# CITY OF ALBUQUERQUE

April 6, 2018

RE: **Global Storage- Coors**  
**3421 Coors Blvd NW**  
**Grading and Drainage Plan**  
**Engineer's Stamp Date 03/2018**  
**Hydrology File: G11D071**

CONCEPTUAL
GRADING &
DRAINAGE PLAN
1 OF 2

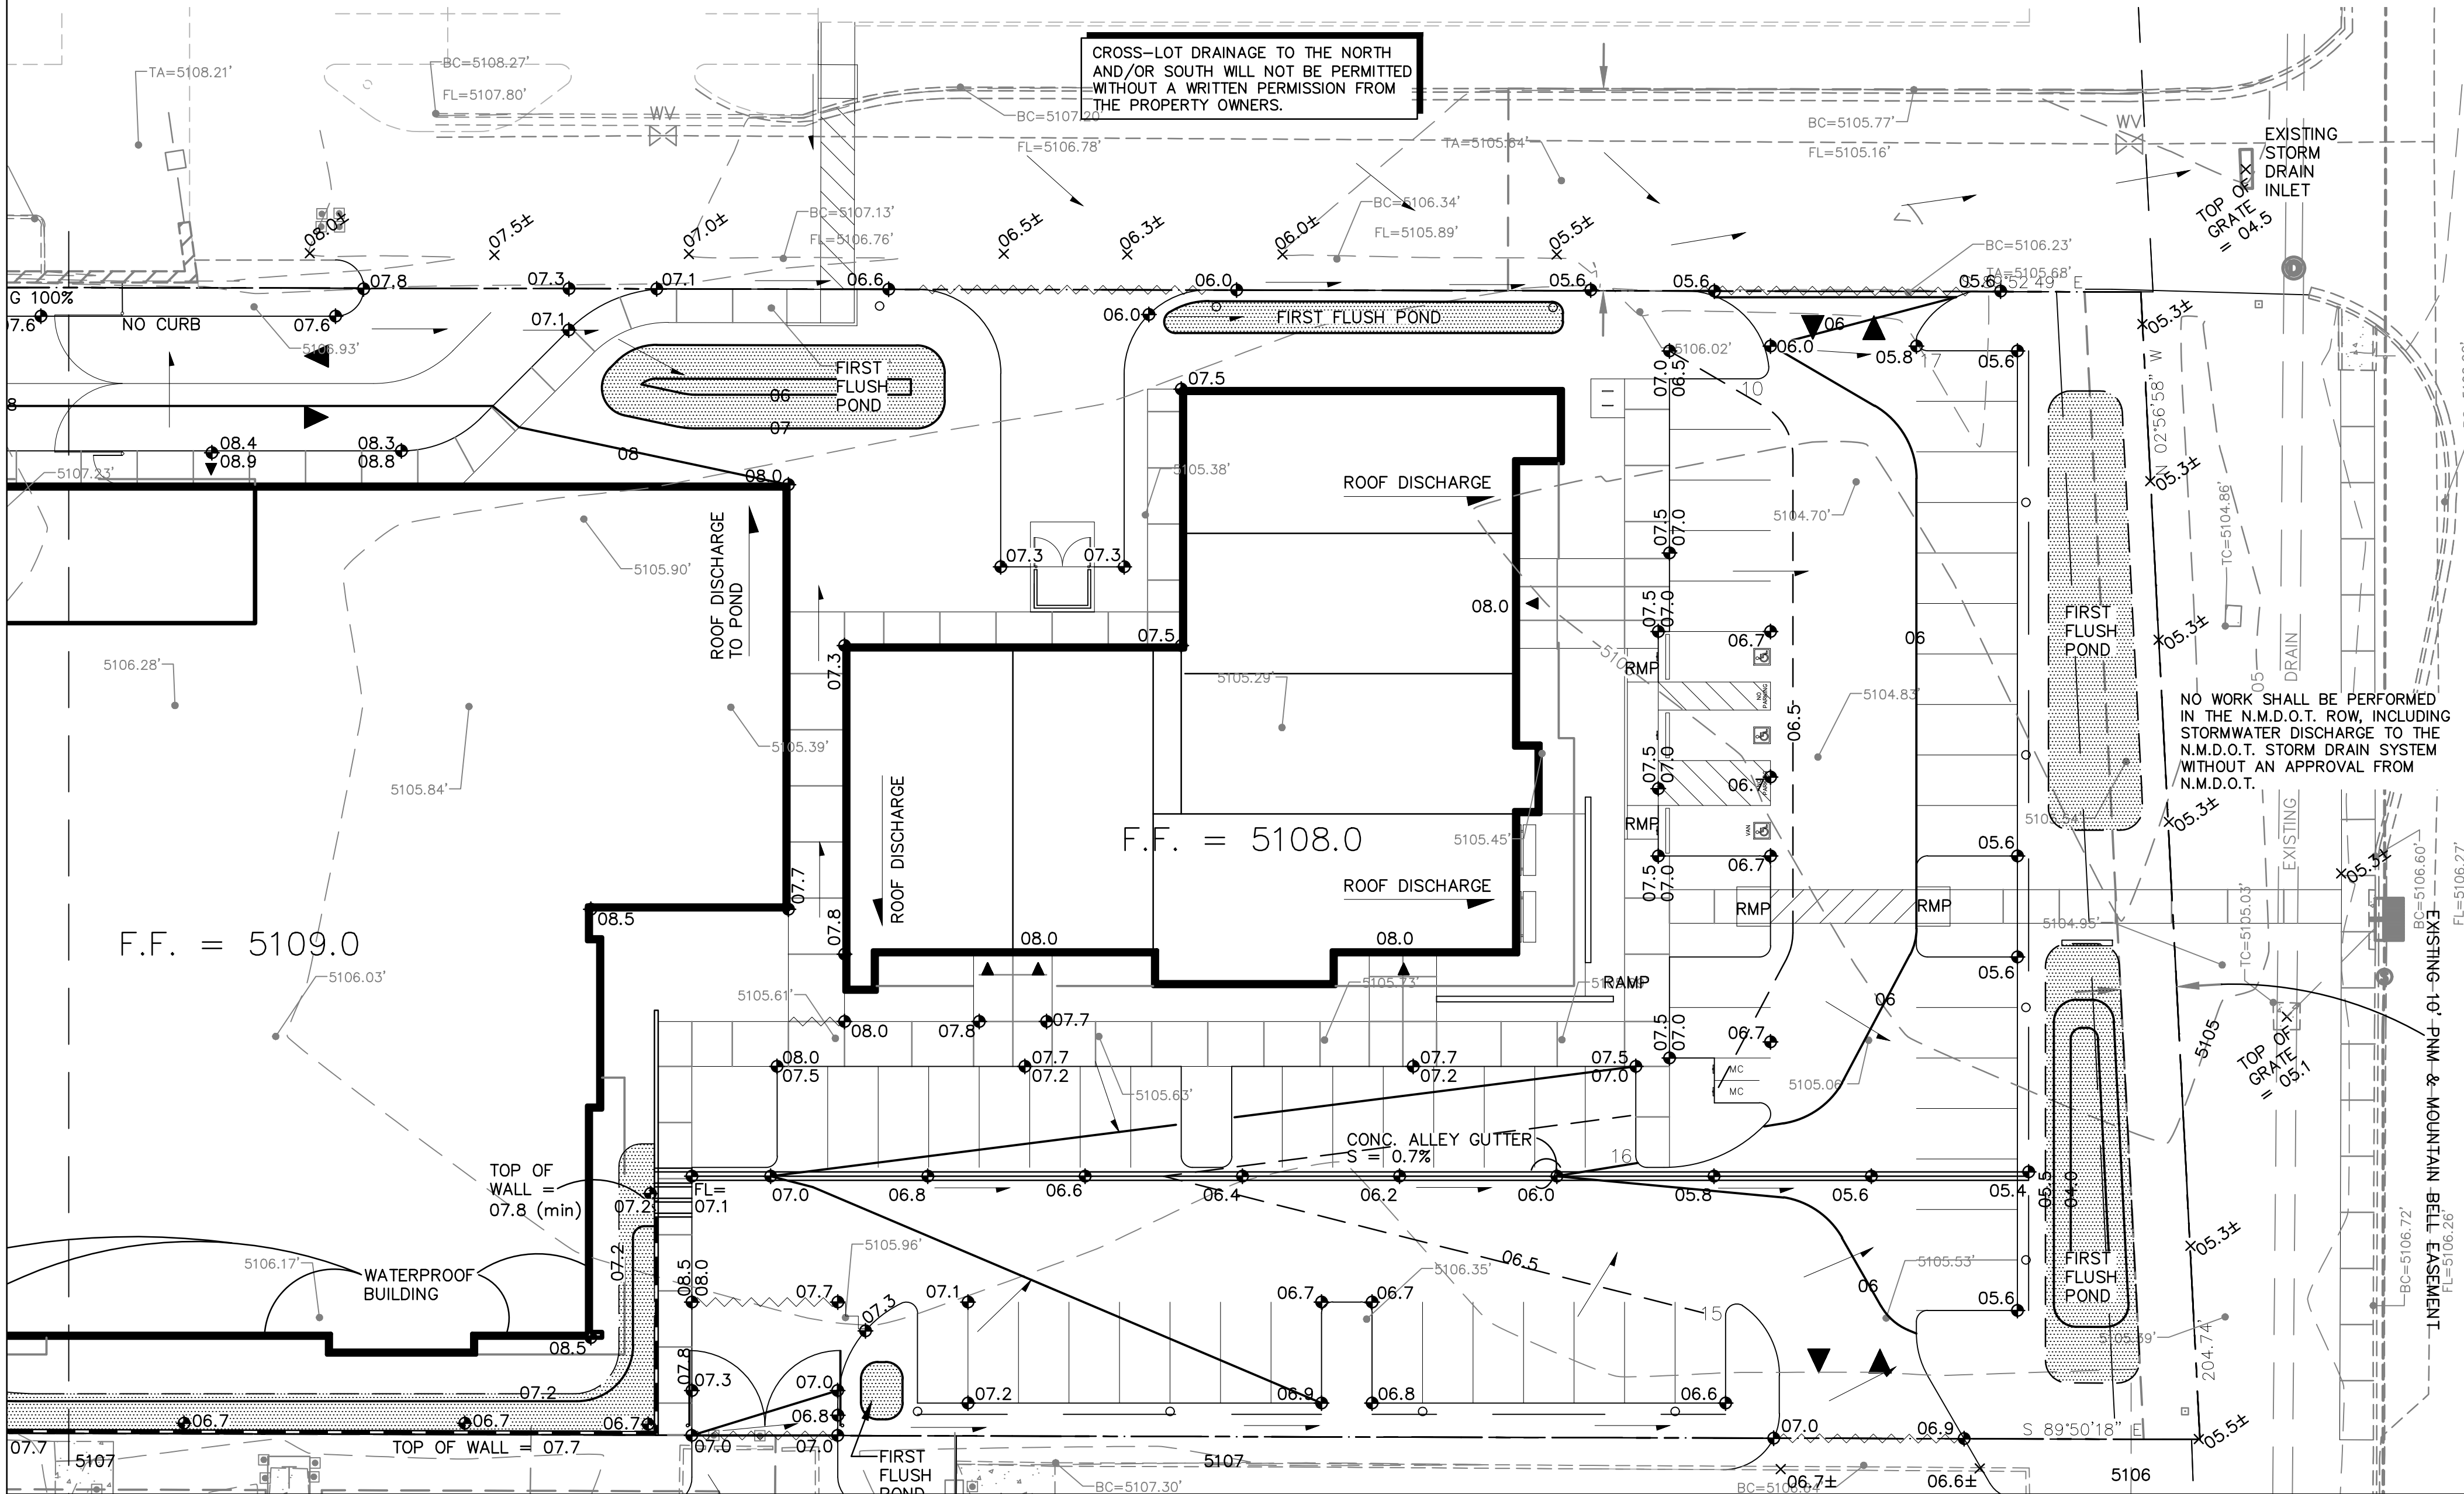
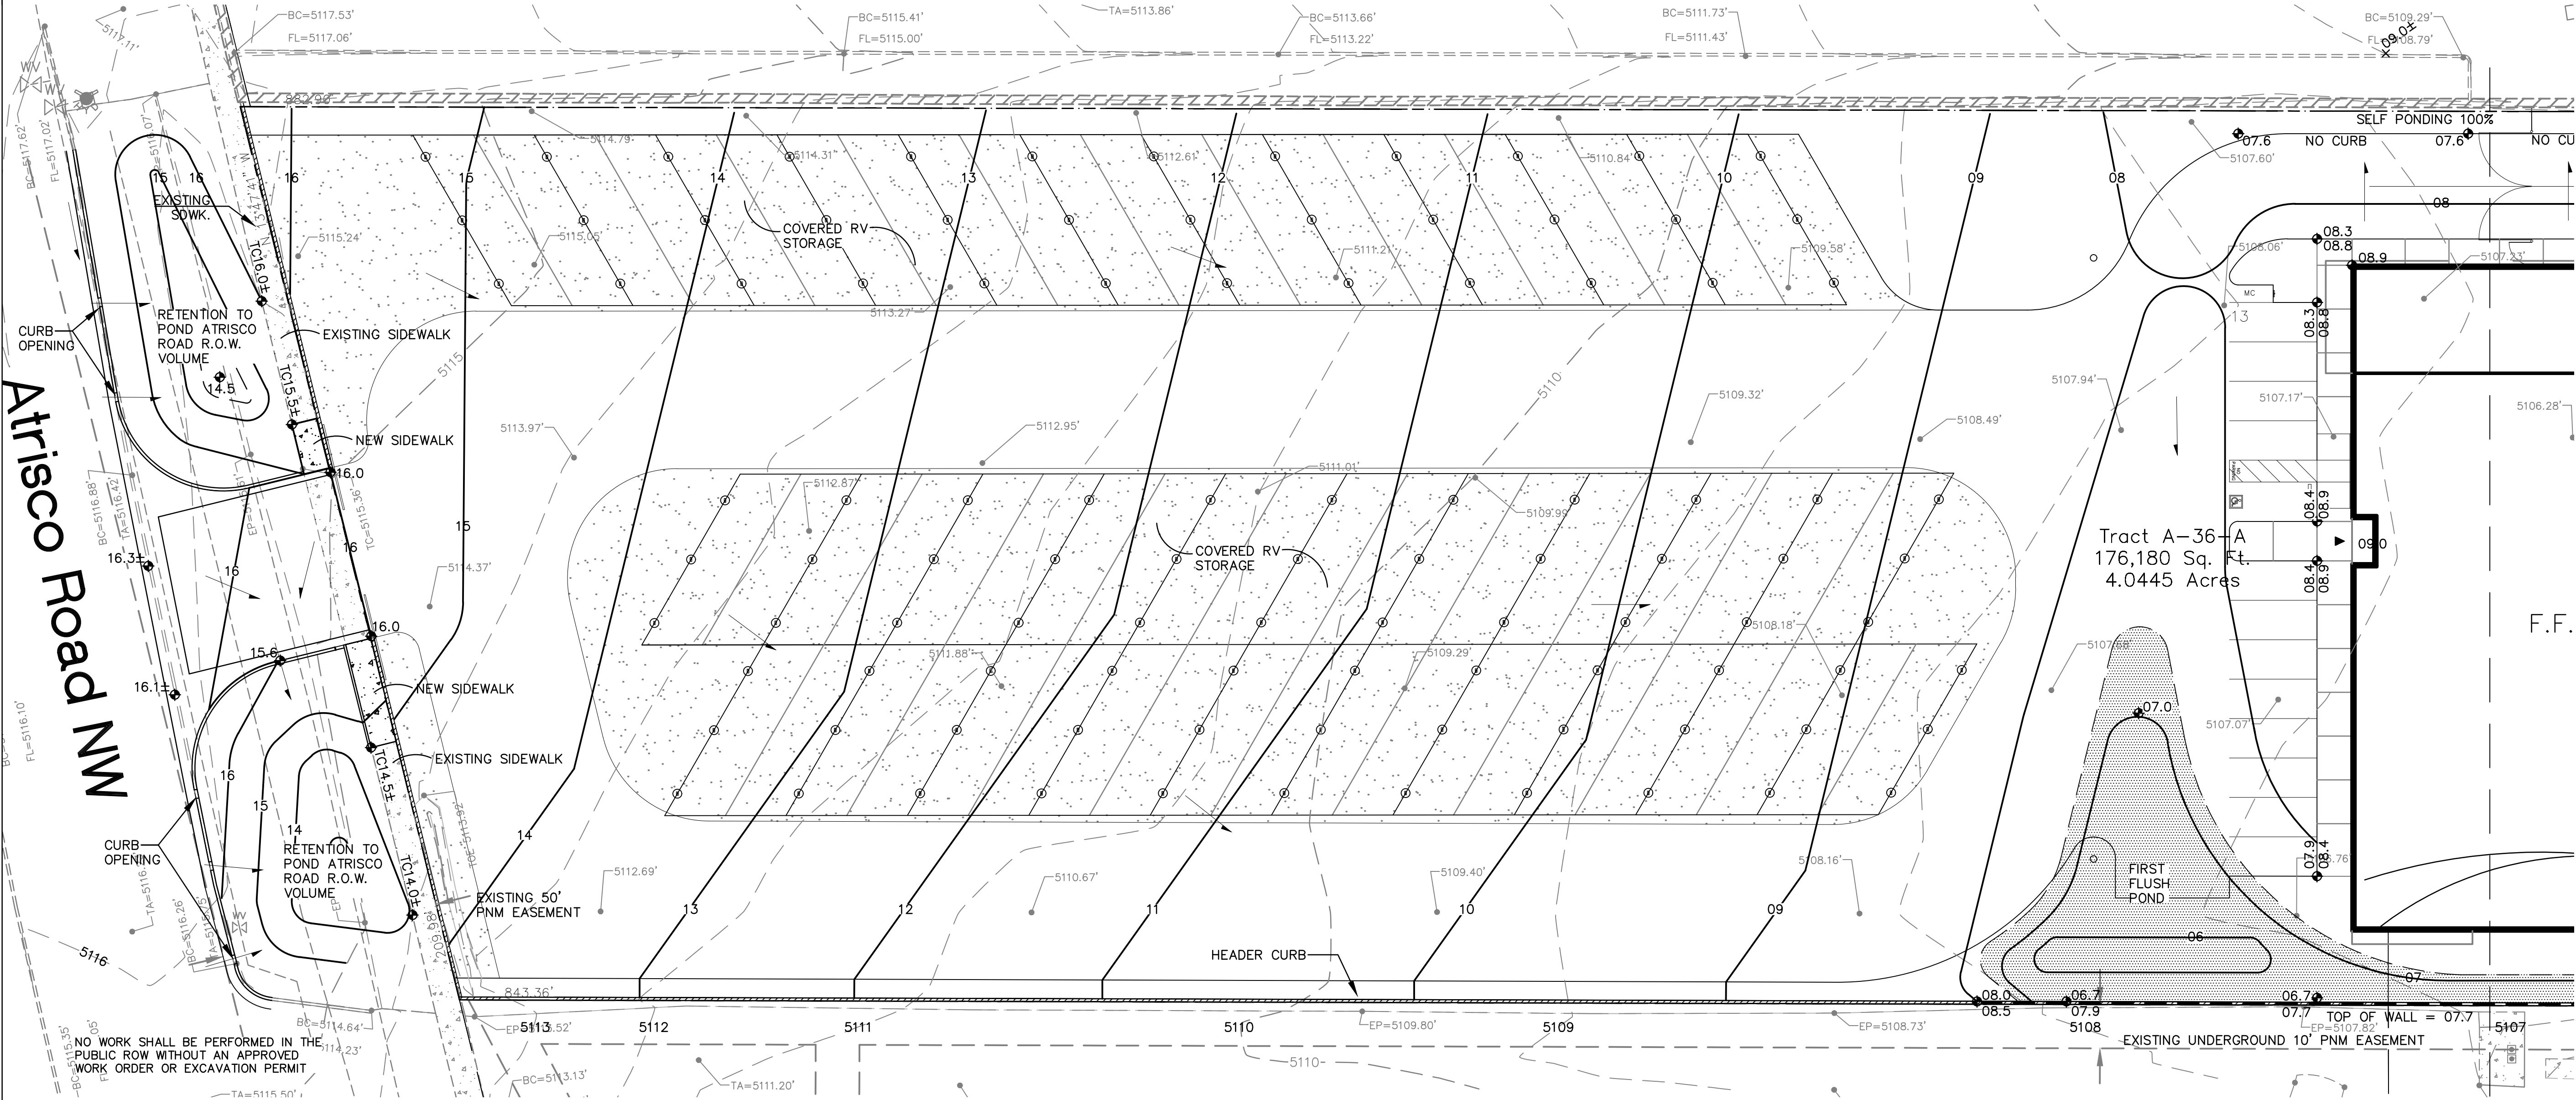
1. This site discharges to Coors Blvd, an NMDOT facility. Written concurrence must be obtained from NMDOT D3 Drainage that this project can proceed. Please contact Tim Trujillo P.E (TimothyR.Trujillo@state.nm.us).

2. Add note on the plan that "No work shall be performed in the public ROW without an approved Work Order or Excavation Permit."
3. Provide written permission from the property owners to the north and south for the work on their properties to build the new driveway entrances onto this property. If there will be cross-lot drainage occurring at these new access points, that permission should be included as well. Since an access easement will likely be required, the drainage language can likely just be added to that.

4. Provide additional spot elevations along the property line in order to assess the need for cross-lot drainage easements.
5. There appear to be a few areas where impervious areas are not being retained on-site, such as at the driveway entrances and the dumpster access. Please clarify these basins. If unable to capture and retain on-site, quantify the first flush bypass volume and state on plans. Payment of fee in-lieu will then be required at building permit.

6. Please clarify areas of impervious vs. pervious surfacing. For instance, Basin 1 seems to be nearly all asphalt and concrete but is claimed as only 75% impervious. Provide a larger basin delineation map showing impervious vs. pervious areas and include a scale.
7. Along Atrisco, provide curb openings and size the retention areas to be able to pond the portions of Atrisco that drain to them. Since this will all occur within the ROW, a work order, or excavation permit at minimum, will be needed.
8. Either a recorded SIA with financial guarantee or close-out of the public work order is required prior to final sign-off of the Site Plan.
